COMMUNITY SERVICES DEPARTMENT

April 21, 2022

Subject: Sand Creek Channel Design and Construction Documents, Review #4 (CDR-20-004)

C201

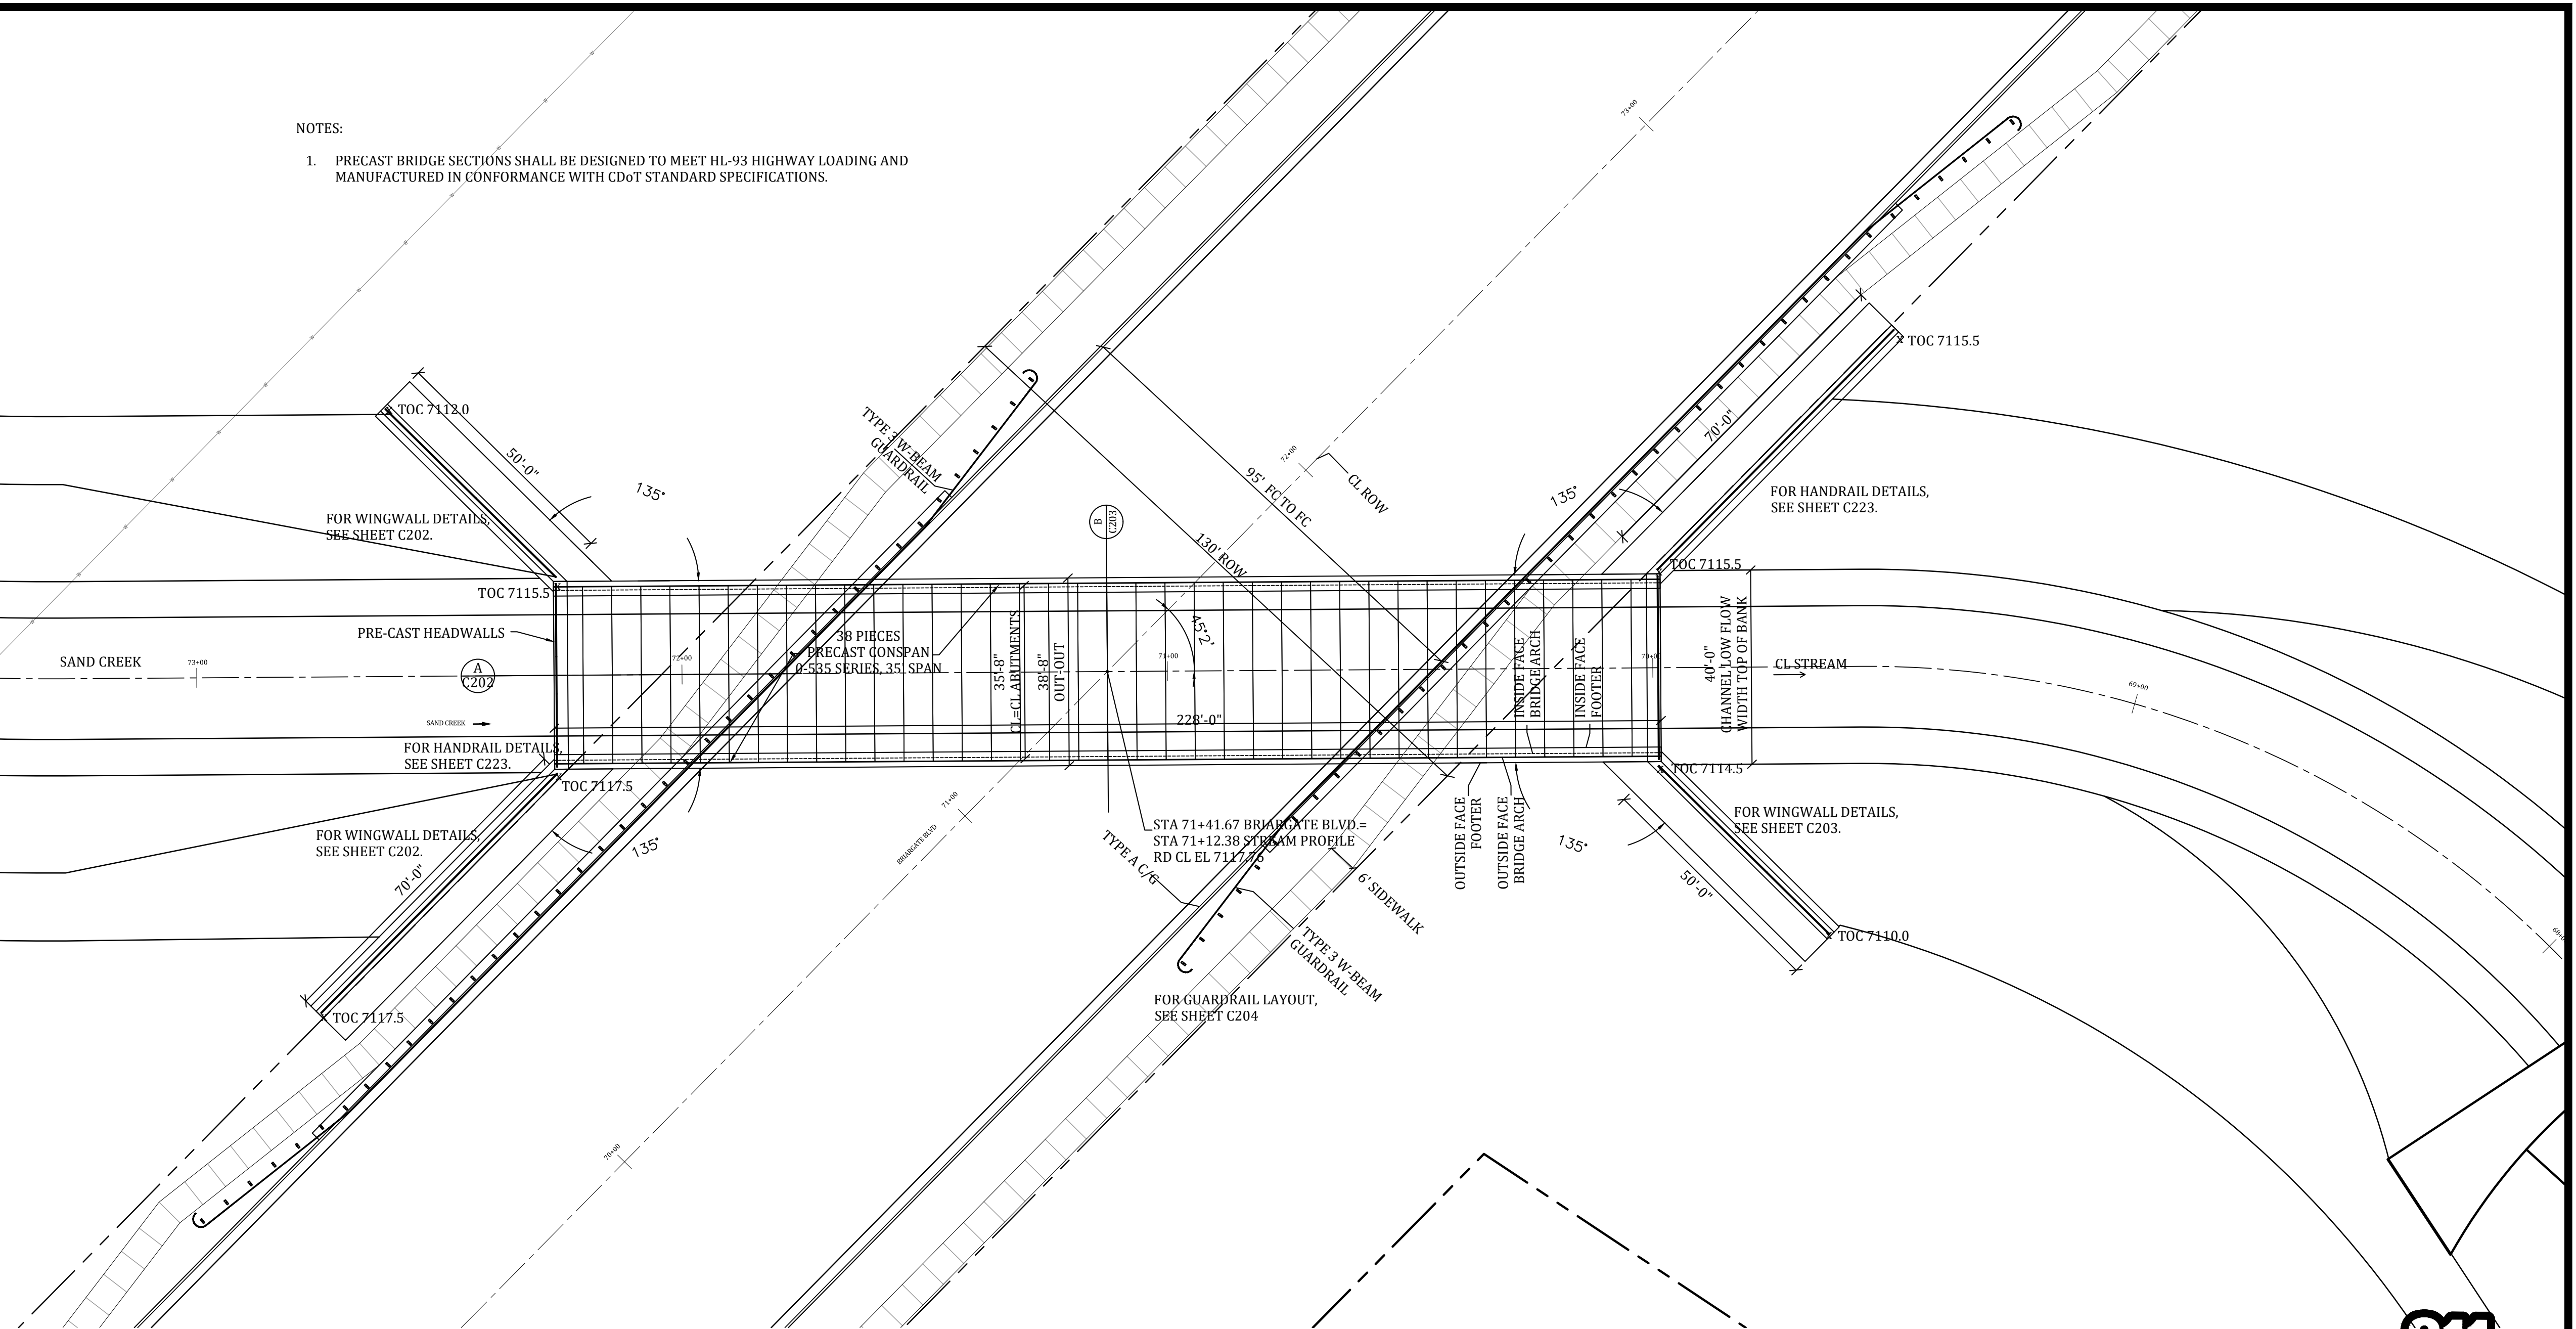
Pages C202 and C204 of the Construction Documents show the Briargate Boulevard Bridge design, including the locations of the proposed 6-foot wide sidewalk and guardrails, while a detail on C222 provides the general cross-section for the guardrail and sidewalk on either side of the bridge. Staff understands the constraints of routing the previously recommended 10' concrete sidewalk and 5' gravel trail across the bridge, between the wingwalls and guardrails for Briargate Boulevard, and further recognizes that certain aspects of the sidewalk and adjacent gravel trail may need to be modified and possibly narrowed within the bounds of the bridge structure. Staff recommends the applicant and designers show the approaches of the sidewalk and adjacent trail on the C202 or C204 layouts."
